Addendum No. 1

RE: Contract # C204434

BRIDGE 138 AND BRIDGE 139 OVER THE NEUSE RIVER ON SR-1470.

The following revisions have been made to the Structure plans.

PP 36 X 0.50 GALVANIZED STEEL PILE
(CLOSED END)

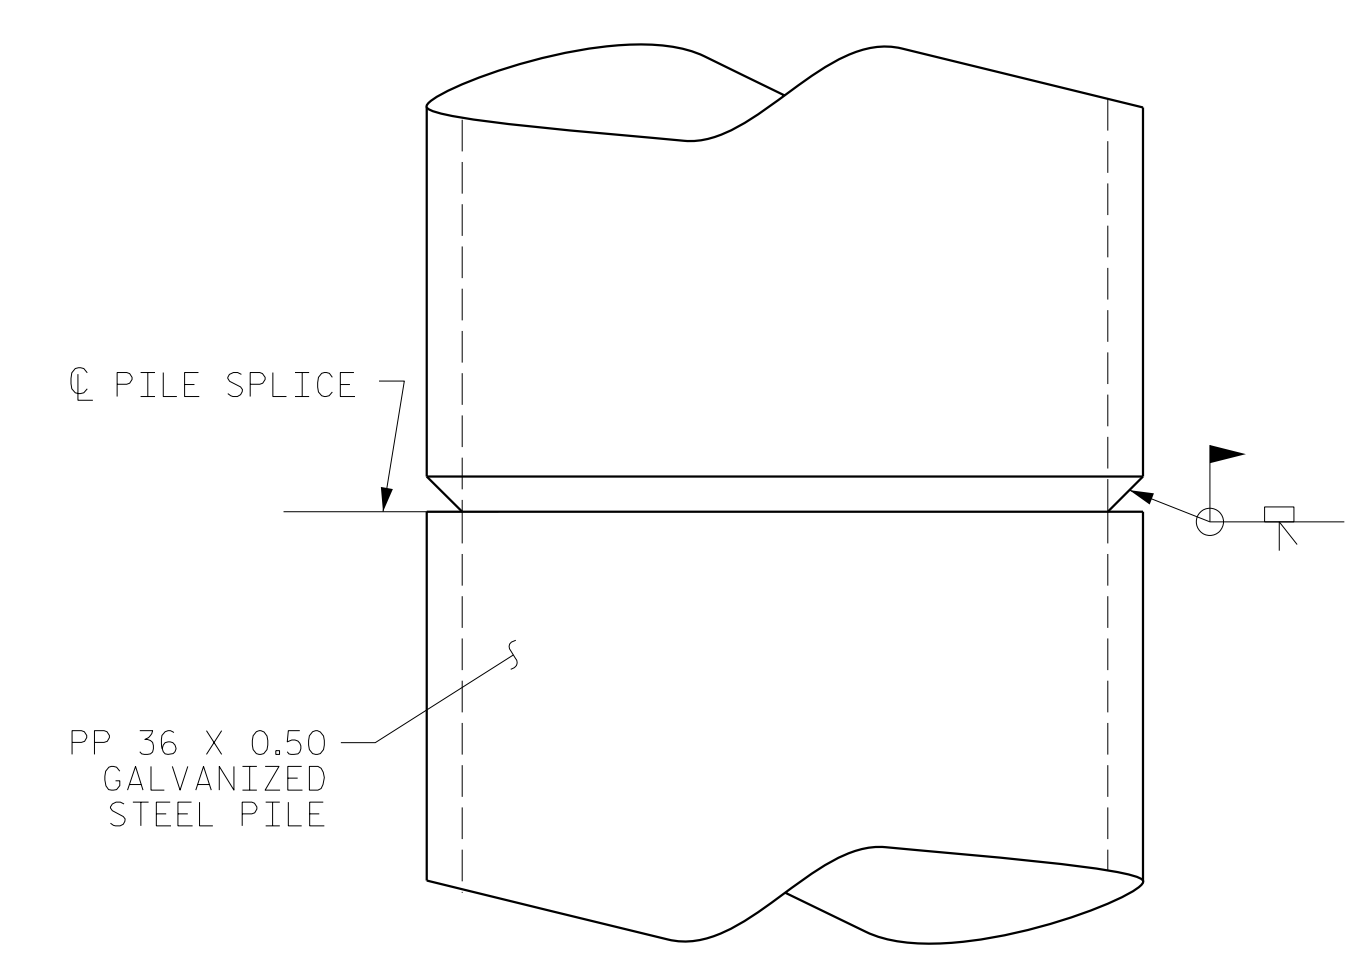
Sheet No.	Revision
S1-31	Revised to show a Steel Pile Point on the end of the 36" Steel Pipe Pile, rather than a Pipe Pile Plate
